PLANNING CONSULTATION RESPONSE

Application No	2026/0293
Proposal	Installation of new raised driveway access, dropped kerb and alterations to access the entrance area of dwelling.
Address	16 Tollgate Close, Shafton, Barnsley, S72 8QX
Date of Consultation Reply	30 th June 2026
Consultee	Highways DC

[2nd response]

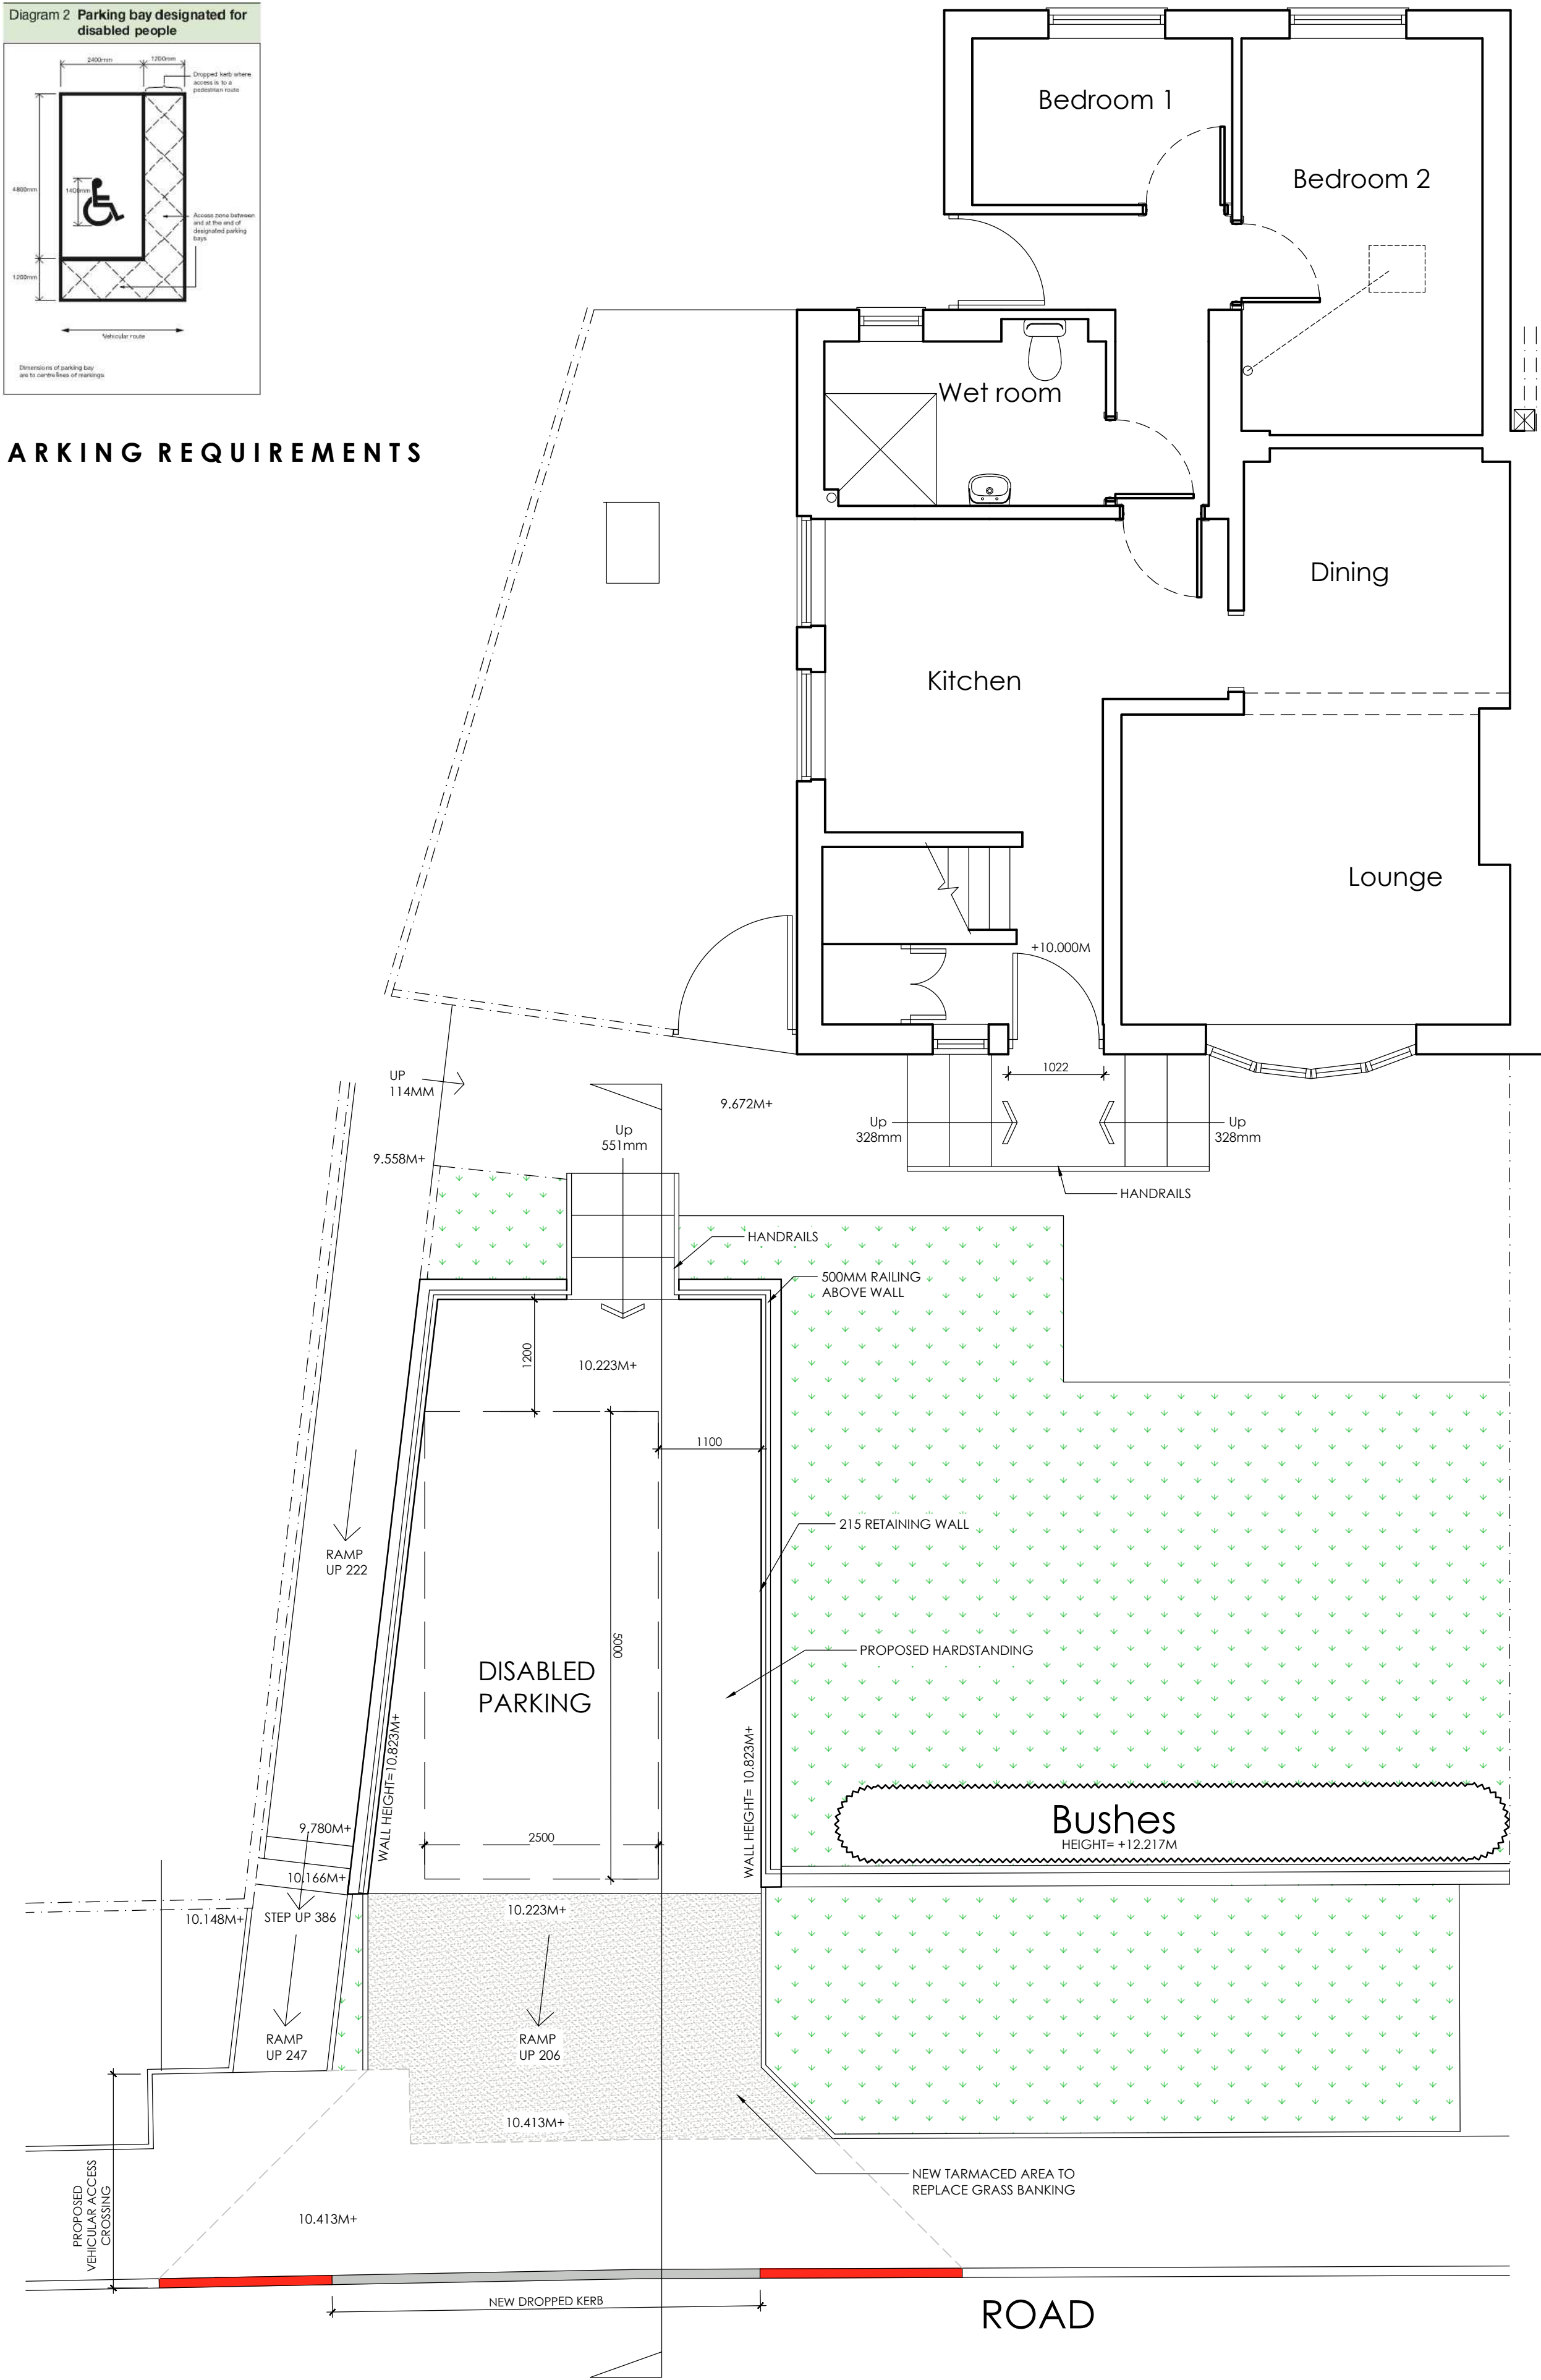
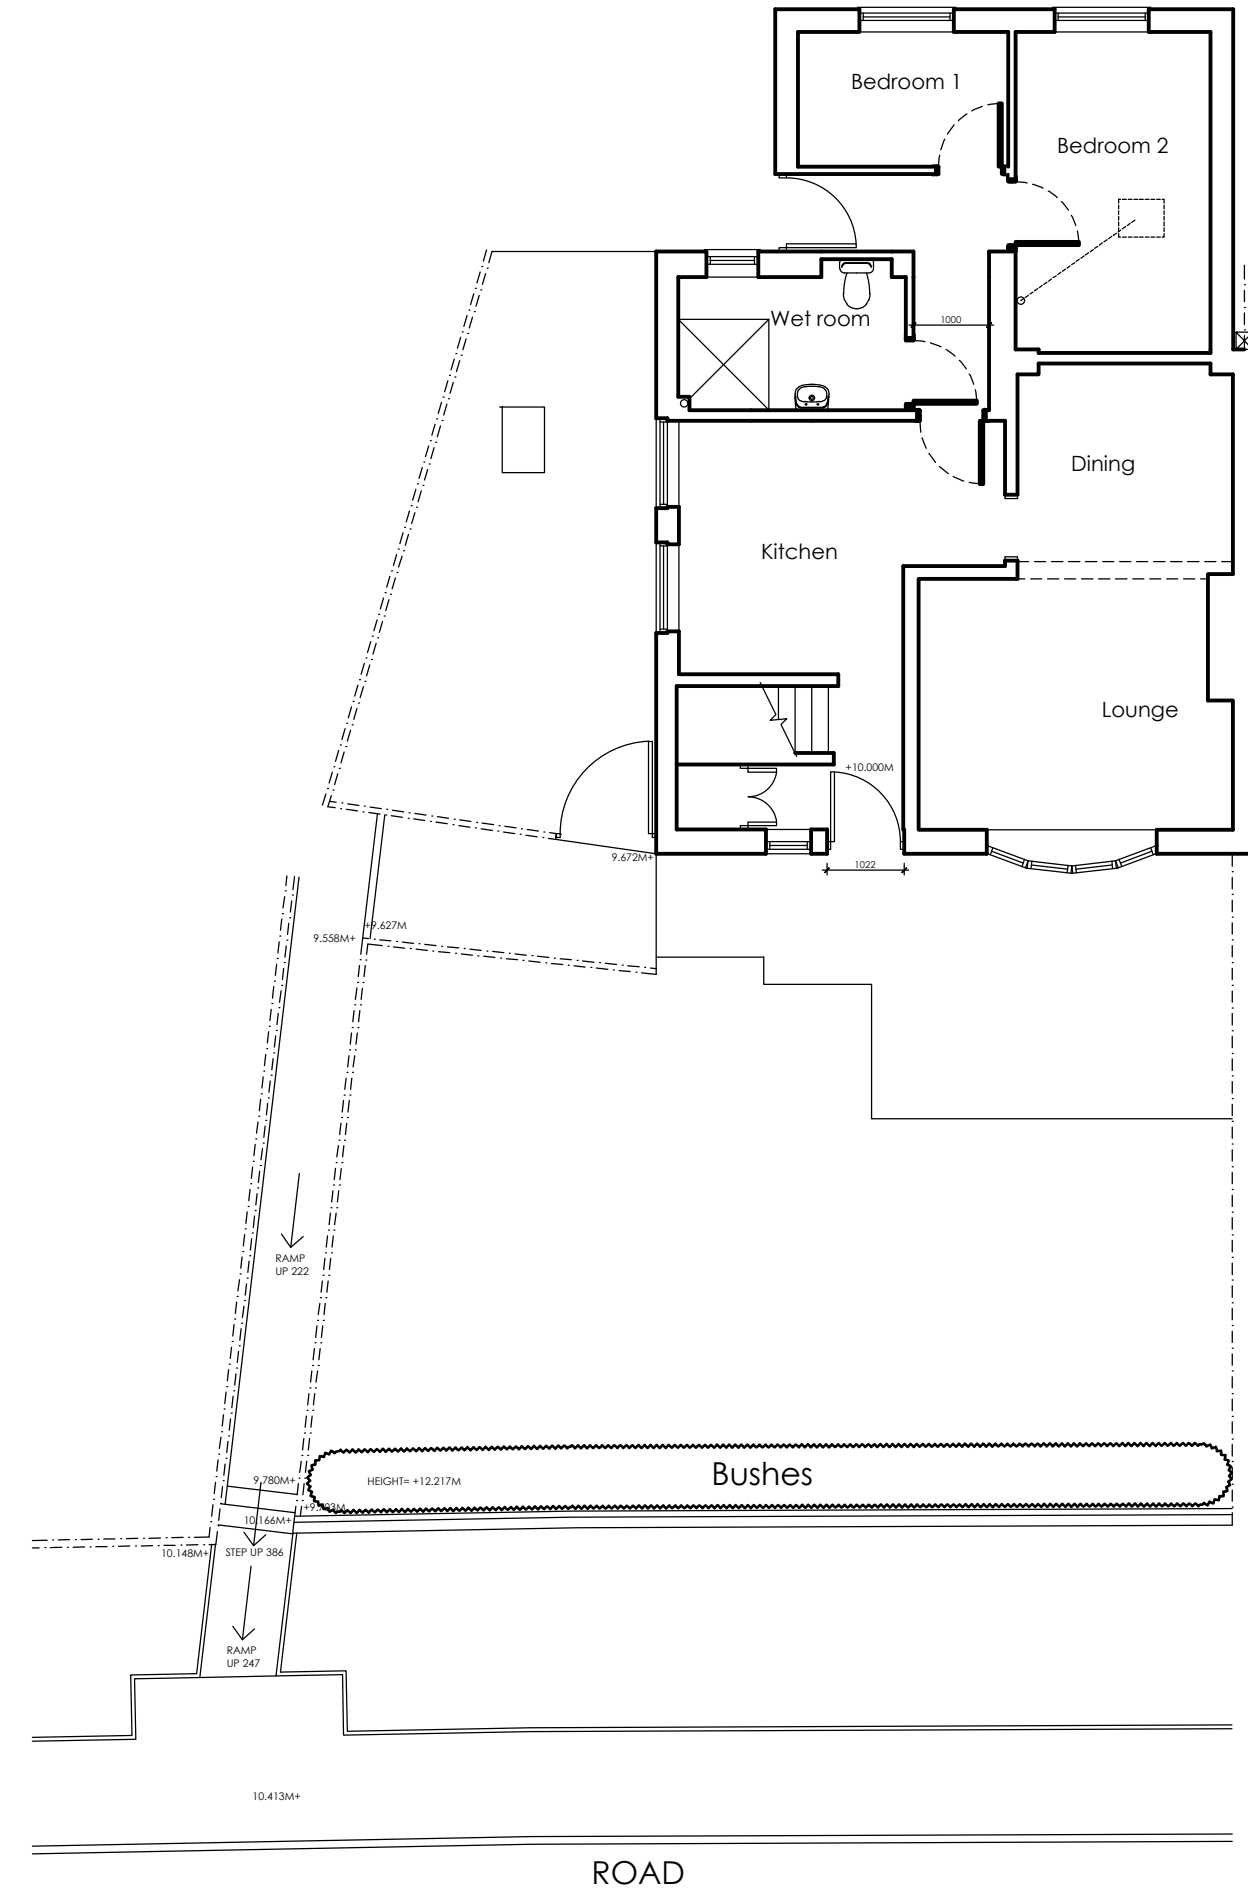
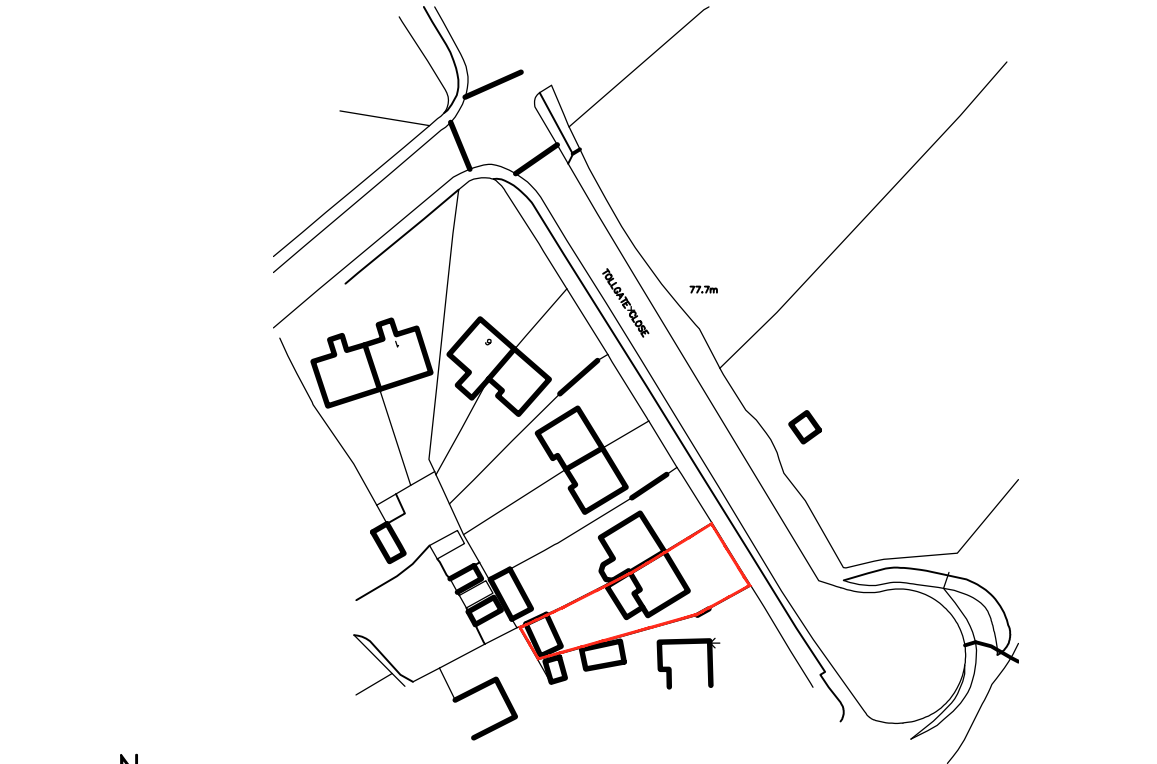
With reference to the amended drawing no. 23-158 04 Rev. B, it can be seen that the ramped access across the grass verge area is to raise 206mm which, over the distance between the site boundary and the back of the footway equates to a gradient of 1:12; this is now acceptable from a highways point of view.

The proposed dropped kerb vehicular access across the footway and verge does not include any raised edgings or handrails etc. as such, the maintenance of the grass verge by council operatives would not be impeded.

The gradient of the vehicular access/driveway shall not exceed 1 in 12 as measured from the edge of the adjacent carriageway.
